CITY OF ALBUQUERQUE

**Re: Casitas de Albuquerque
1016 Lead SW
30-Day Temporary Certificate of Occupancy- Transportation Development
Transportation Development Final Inspection
Engineer's/Architect's Stamp dated 3-28-17 (K13D075)
Certification dated 12-28-18**

TRAFFIC CERTIFICATION

SITE PLAN

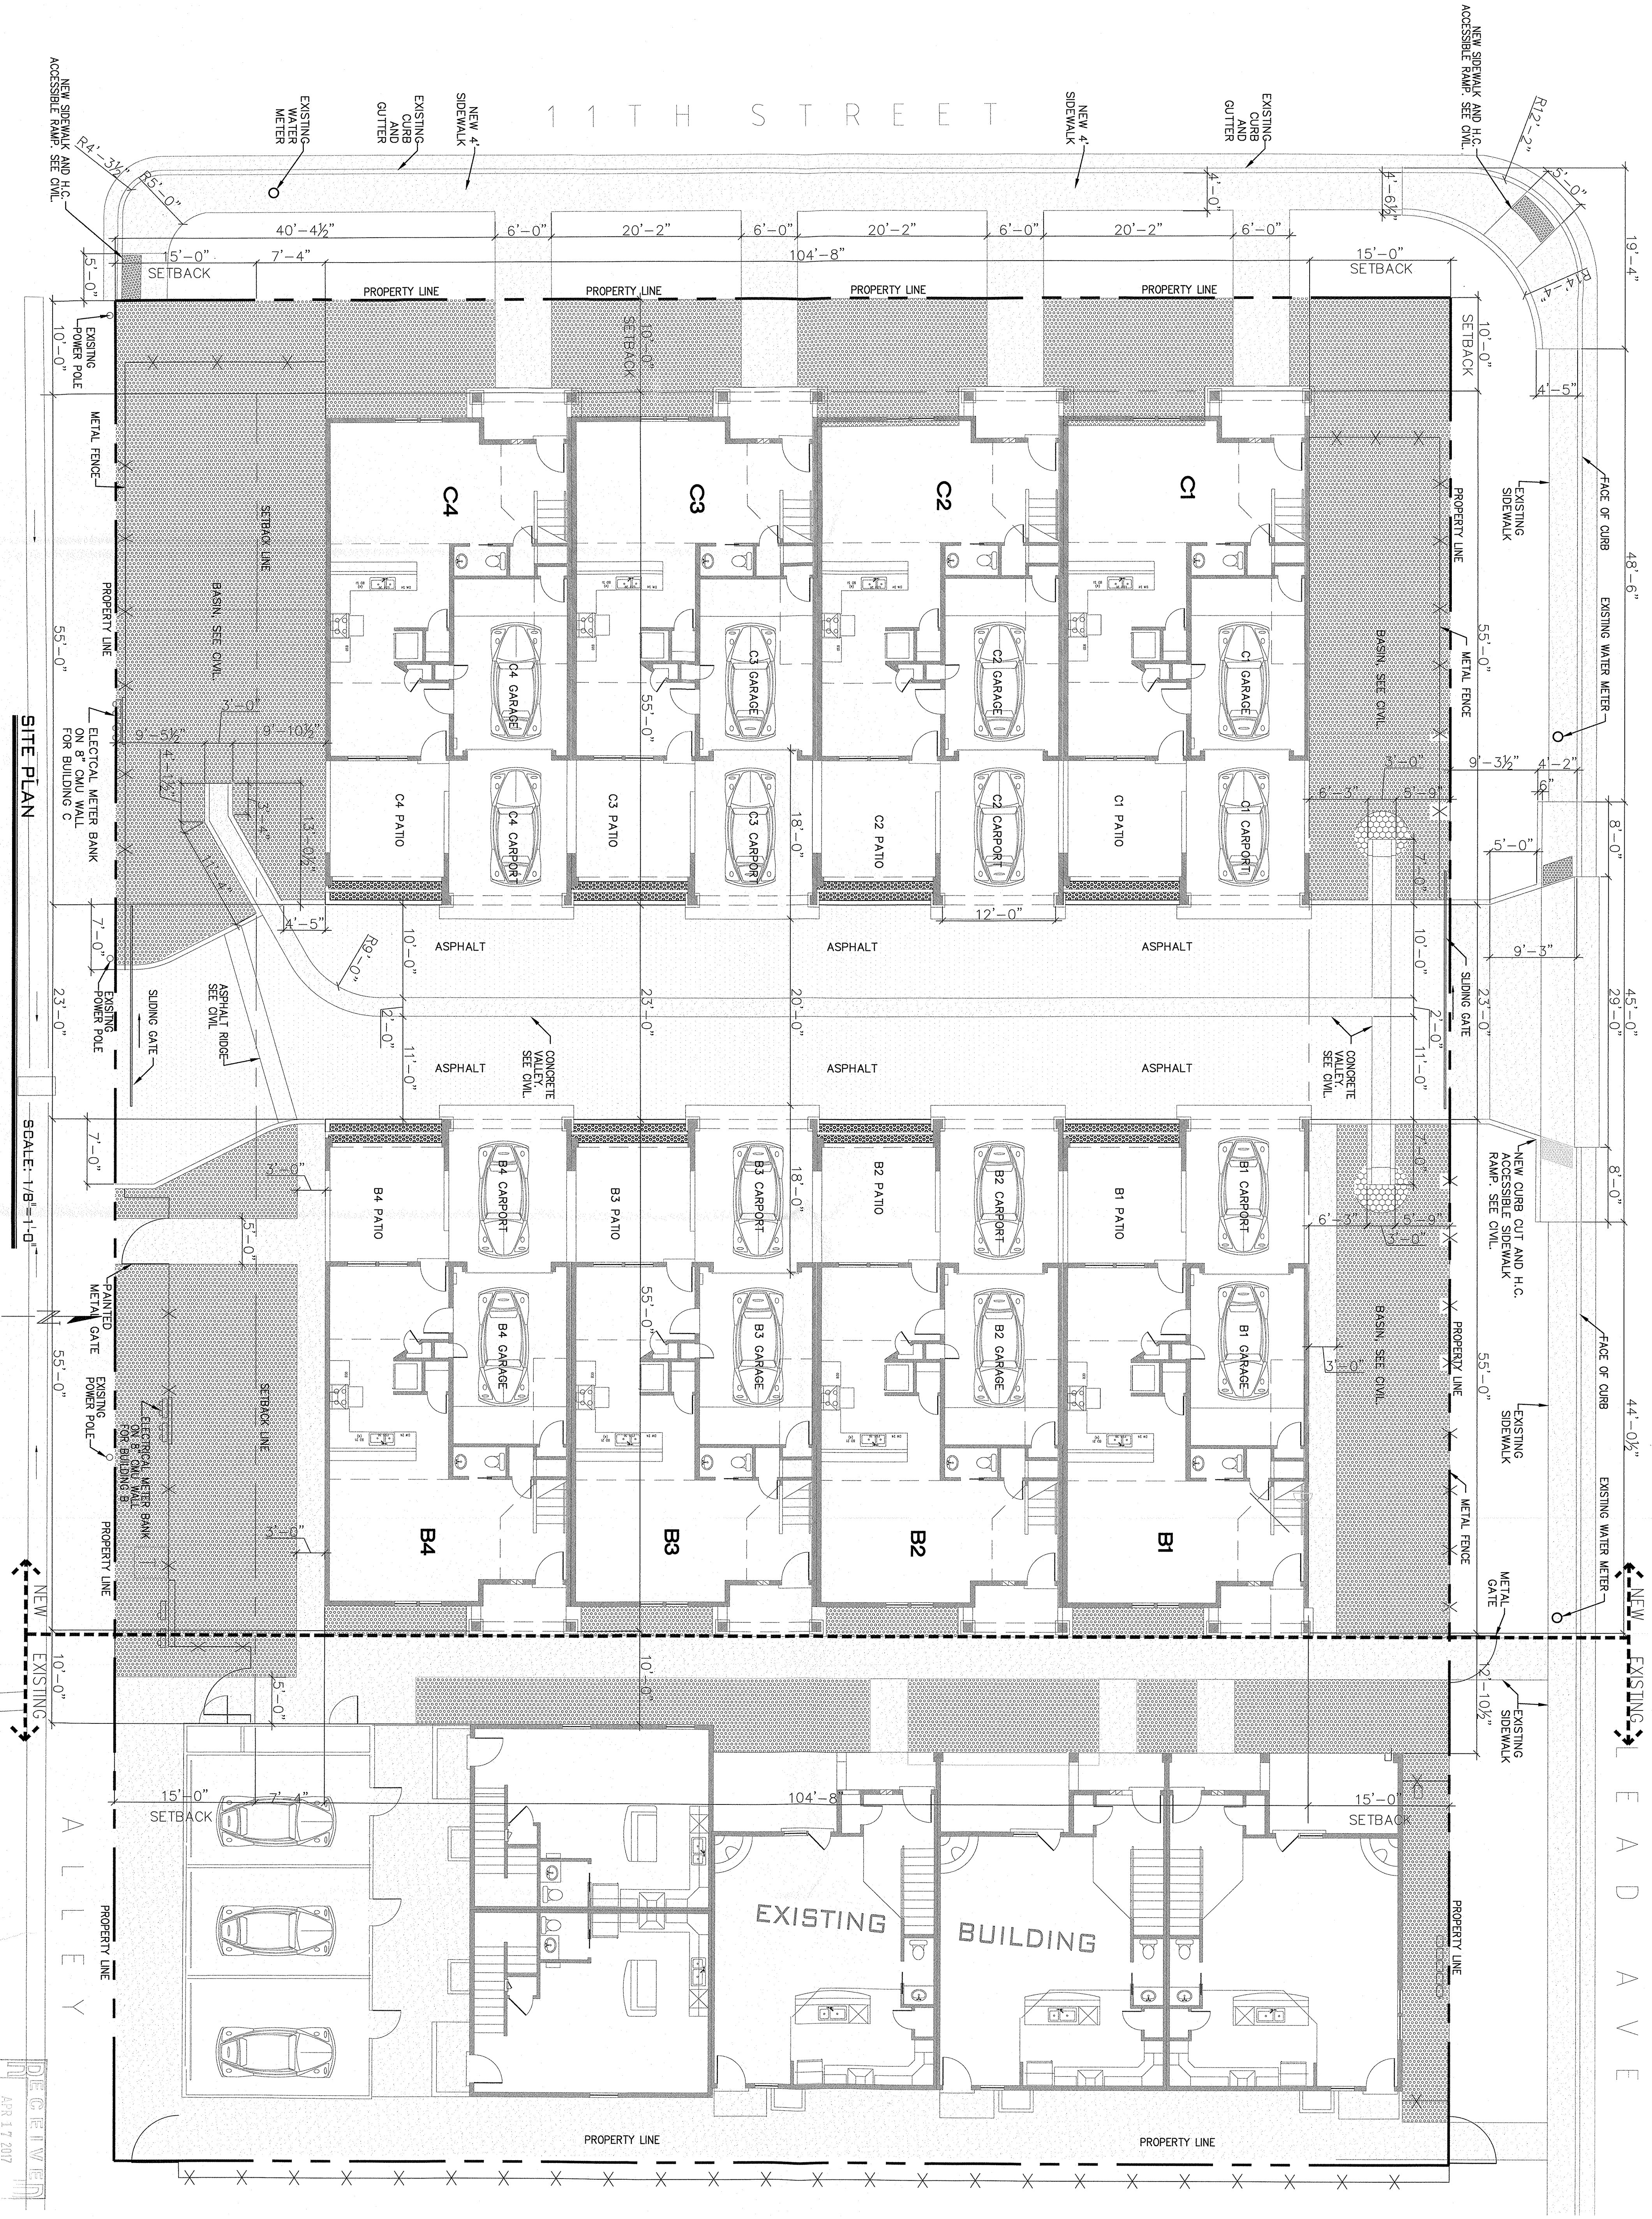
1. Please remove security fence. (Please send Photos of corrections for final CO).
